**RE: Sonata Unit 4 Trails Apartments  
Tracts 1, 2, and 3, The Trails Unit 4  
Third DRB Submittal**

RESPEC, agent for Sonata Trails, LLC, owner of the above referenced property, is requesting approval from the Development Review Board (DRB) on this Site Development Plan submitted for your consideration. This is the second submittal to the DRB for this project. The first hearing was held on June 3, 2020. Below is a response to comments received at the first DRB meeting.

PROJECT NAME: SONATA TRAILS UNIT 4 APARTMENTS

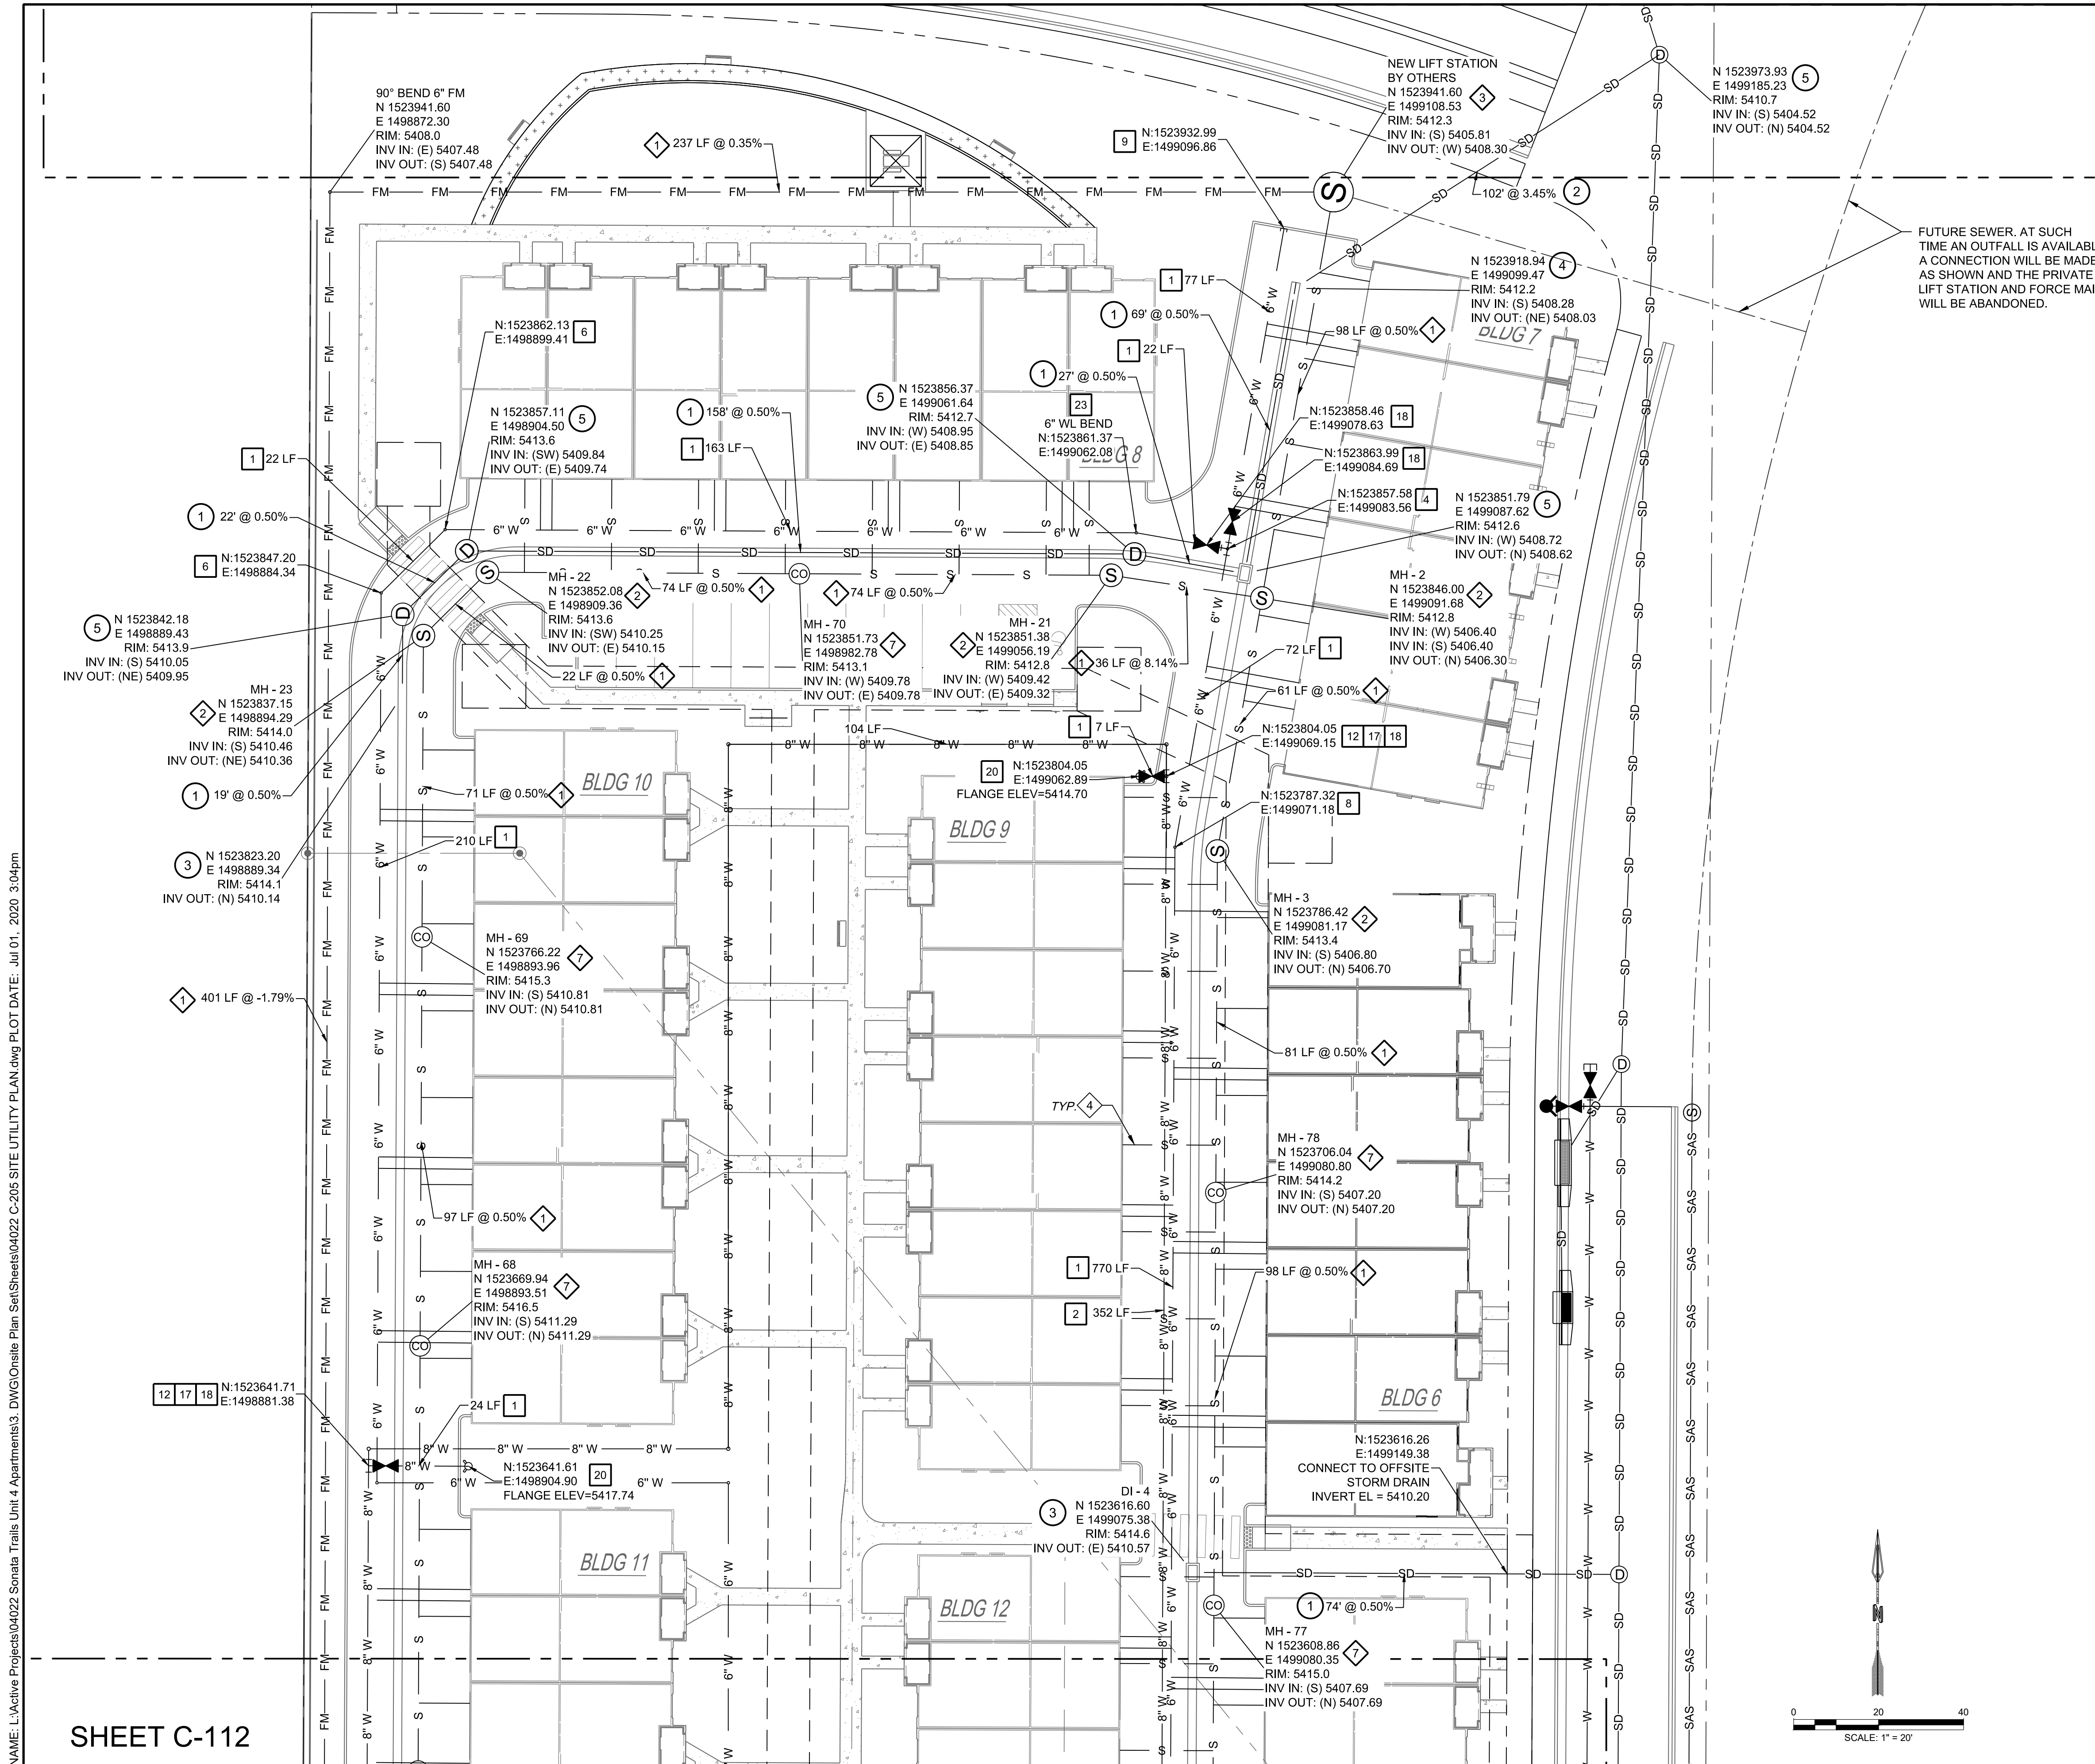
1. The development is outside of the Adopted Service Area. Water Authority Board approval is required prior to Site Plan approval. This will be in the form of a development agreement. The development agreement shall be supplemented by a serviceability letter.
2. A request for availability was received. Serviceability Letter #200426 is currently being researched.
  - a. The official requirements will be stated in the serviceability letter.
3. Utility Plan
  - a. Sanitary sewer
    - i. Construct dry sanitary sewer lines along portion of Treeline Ave. (just enough to provide Tract 3 to the south service) and the entire length of Chatsworth Dr. Label these on the utility plan accordingly.
      1. This shall be reflected on the infrastructure list.
      2. This shall be designed to facilitate future discharge to the future 15" sanitary sewer interceptor.

- ii. The dry sanitary sewer along Oakridge St. can be a deferred item since the roadway will not be constructed at this time. Label this on the utility plan accordingly.
  1. This shall be reflected on the infrastructure list.
  2. This shall be designed to facilitate future discharge to the future 15" sanitary sewer interceptor.

- iii. Construct the public sanitary sewer along Treeline Ave. just enough for a perpendicular service connection.
  - 1. This shall be reflected on the infrastructure list.

- 2. Please confirm if the proposed manhole south of existing manhole C10302 can be eliminated by extending east directly from the existing manhole along Treeline Ave.

- iv. A proposed lift station is shown at the northeast corner of the subject development which ultimately discharges to proposed public gravity sanitary sewer along Treeline Ave. at the southwest corner of the development.

- 1. Considering the potential interim condition with the private lift station, the Utility Plan should show the phases.
    - a. The interim use of a private lift station and the trigger to eliminate the private lift station and discharge to public sanitary sewer that flows to the proposed interceptor along Paseo Del Norte/Avenida De Jaimito when it is available may need to be detailed in the development agreement.

- v. Label proposed lift station and onsite sanitary sewer as private (both force main and gravity sewer).
- / Proposed lift station and onsite sanitary sewer has been labeled as private. See revised utility sheets.

- b. Water
    - i. Differentiate public waterline and private waterline onsite.
- / Labels have been added to differentiate between private and public waterlines. See revised utility sheets.

- ii. Public waterline needs to be shown along Treeline Ave., Chatsworth Dr. and Oakridge St. frontages. Also, an onsite public waterline shall be provided to provide a looped waterline connection. This shall be in an alignment that provides access for maintenance and operation.

- iii. The public waterline along Oakridge St. can be a deferred item since the roadway will not be constructed at this time. Label this on the utility plan accordingly.

/ Dry sanitary sewer added along a portion of Tree Line Ave to serve Tract 3. This is shown on the plan and on the infrastructure list. General Note 13 states that "all utility improvements located within the right-of-way are public." General Note 14 states that "all utilities shown located within the private property shall be private unless otherwise noted." Labels have also been added as well to differentiate between private and public infrastructure. See revised utility sheets and infrastructure list.

/ As you are aware, we are working with transportation and their request to construct our entire roadway frontage surrounding the development. No change has been made

- / Public sanitary sewer along Tree Line Ave for a service connection has been provided and shown on the plan and infrastructure list. The proposed manhole has been eliminated and a tee/wye connection is being proposed. See revised utility sheets and infrastructure list.

- / Public waterline is provided and shown in Tree Line, Chatsworth, and onsite. Water will be shown at the northeast corner and Oak Ridge once further direction is received from Transportation. See revised utility sheets.

- / No change has been made at this time pending determination on how to proceed with this area from Transportation.
